From: [Public Health Inspectors](#)
To: [Zach Torrance-Smith](#)
Subject: RE: VA-23-00007 Chappelle - Notice of Application
Date: Thursday, October 5, 2023 4:42:12 PM
Attachments: [20-14-22051-0005 Nance.pdf](#)

Subject: VA-23-00007 Chappelle - Notice of Application

Drawing name: **PRELIM SITE MAP**

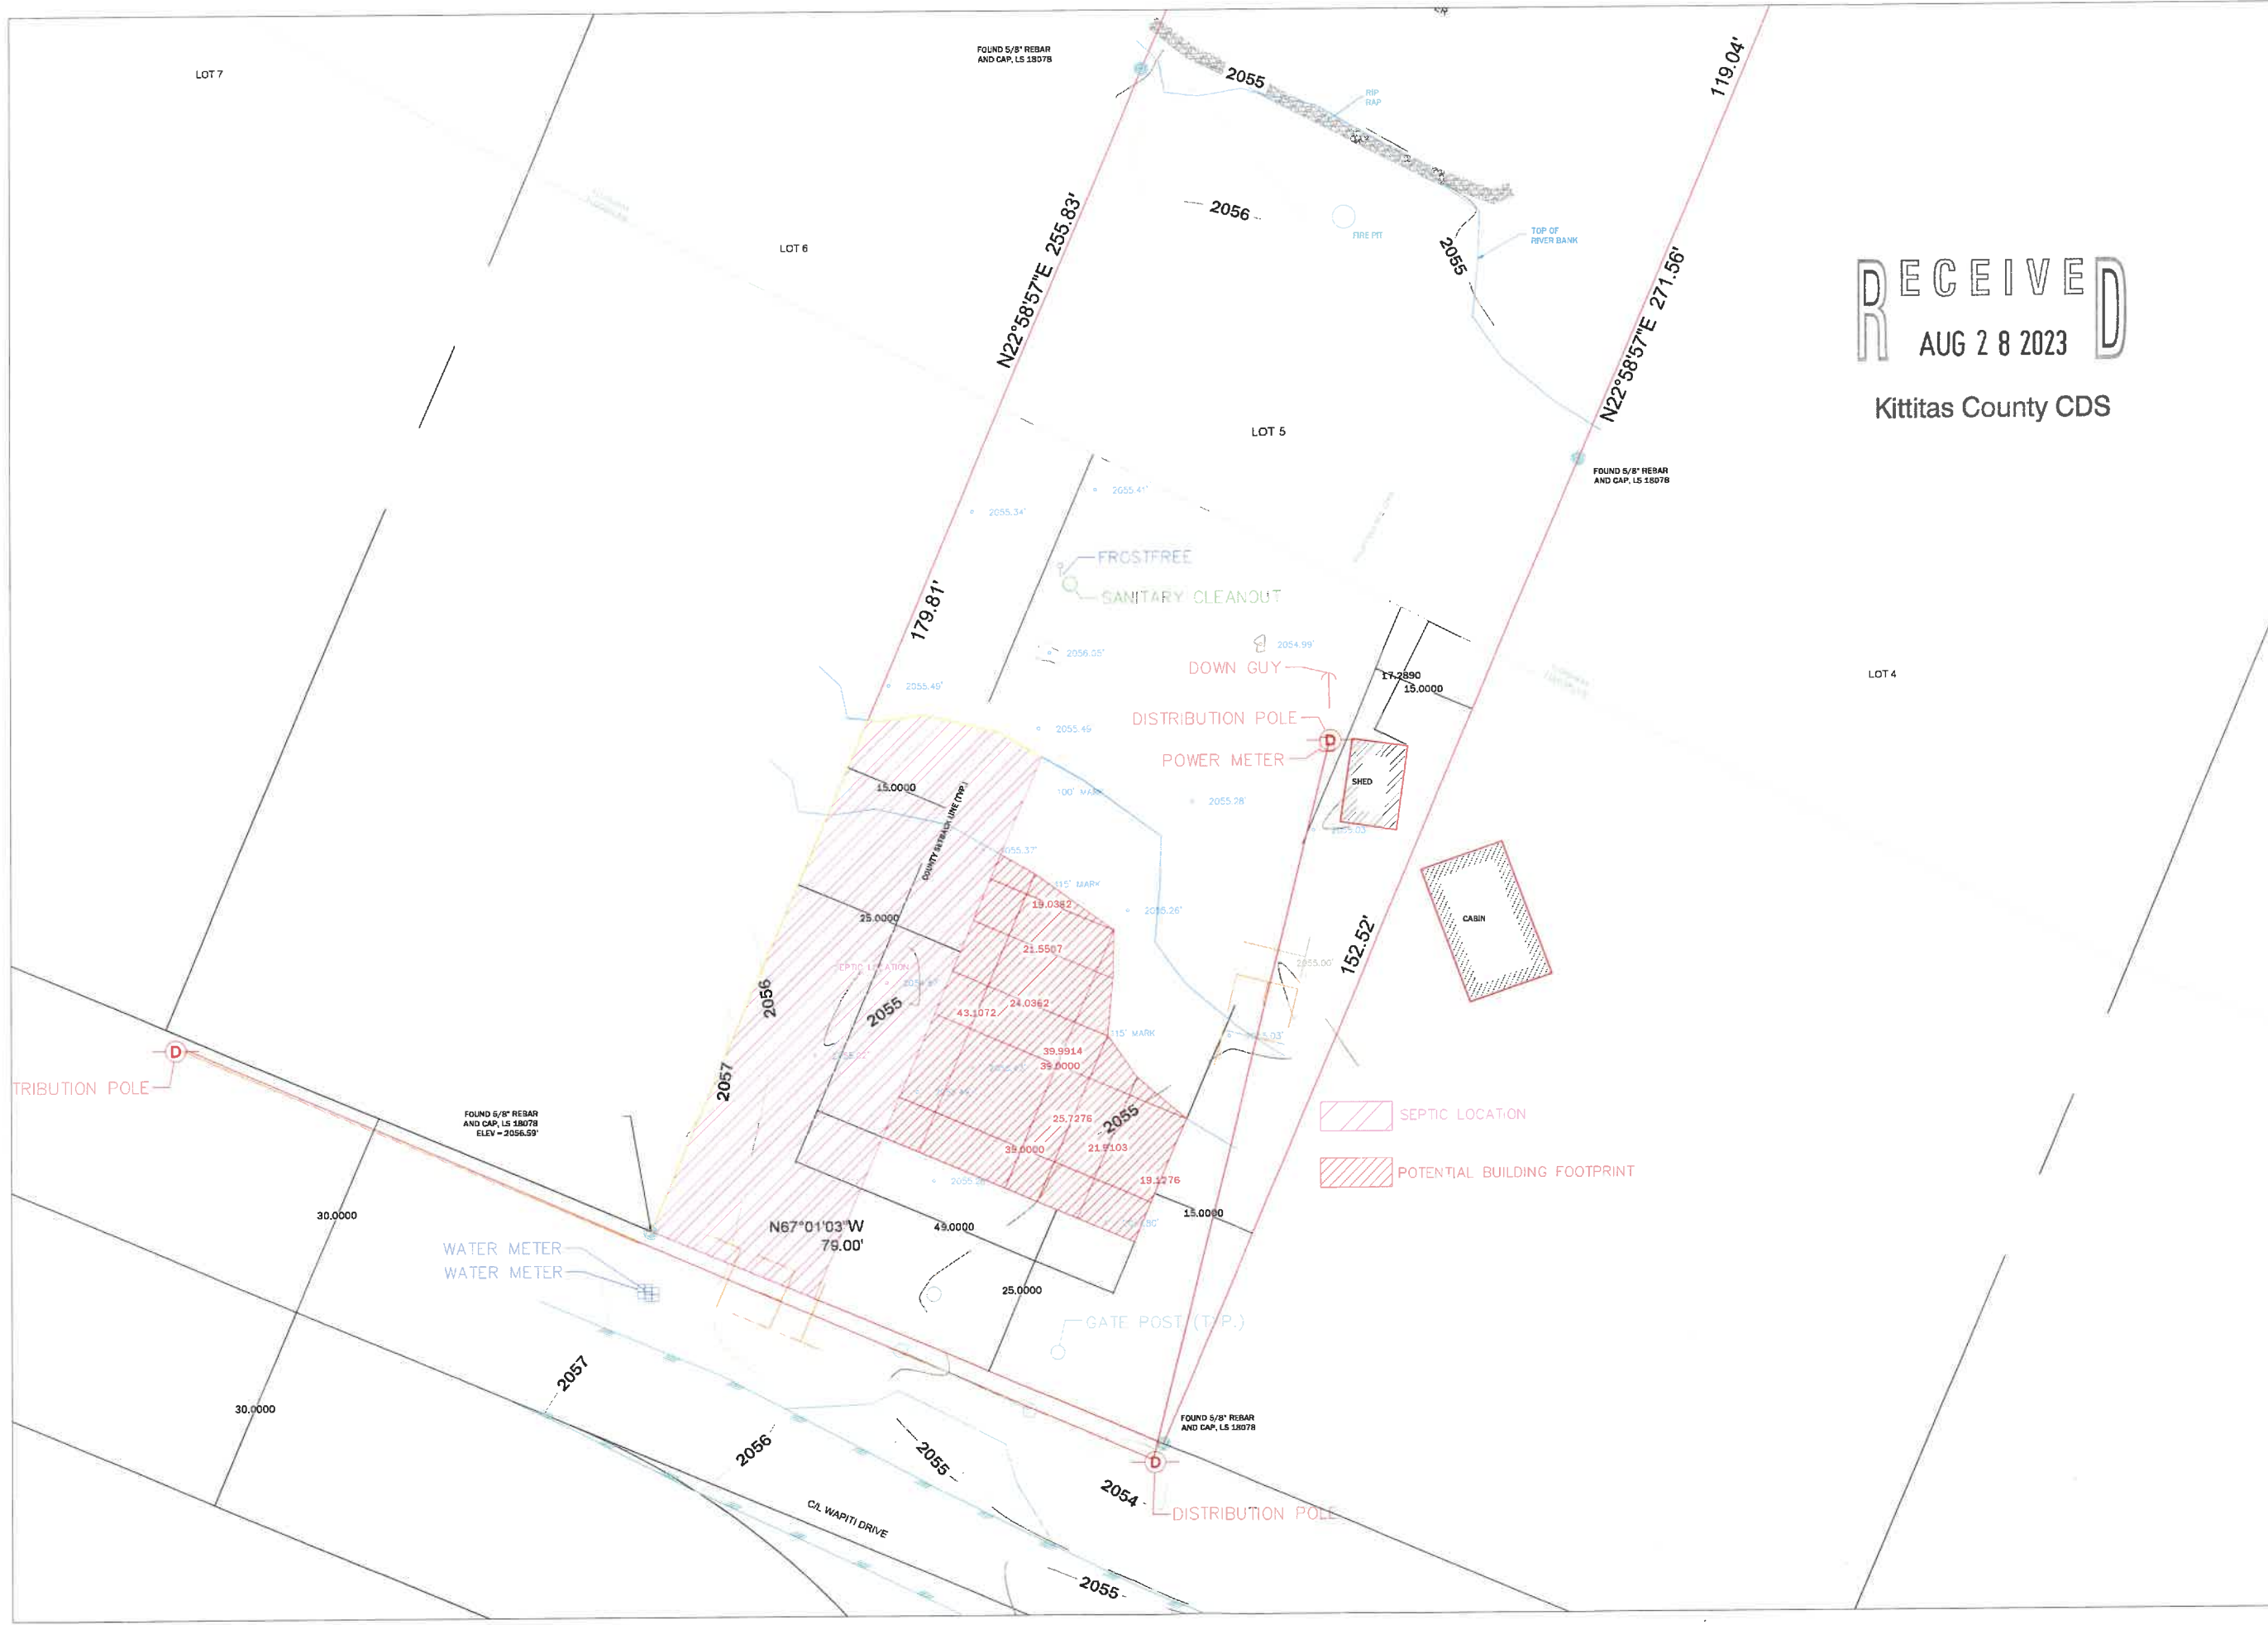
This application is a concern as the existing septic system (attached) is old (1977) and only for a 1 bedroom house. Replacing this system or the potential of adding more bedrooms to the cabin with current codes, found in WAC 246-272, could present a problem as the lot is small and the proposed footprint of the house could take up space that may be required for the future septic system and/or the replacement septic system. A site evaluation should be done to evaluate if there is adequate space on the lot prior to final approval of this application.
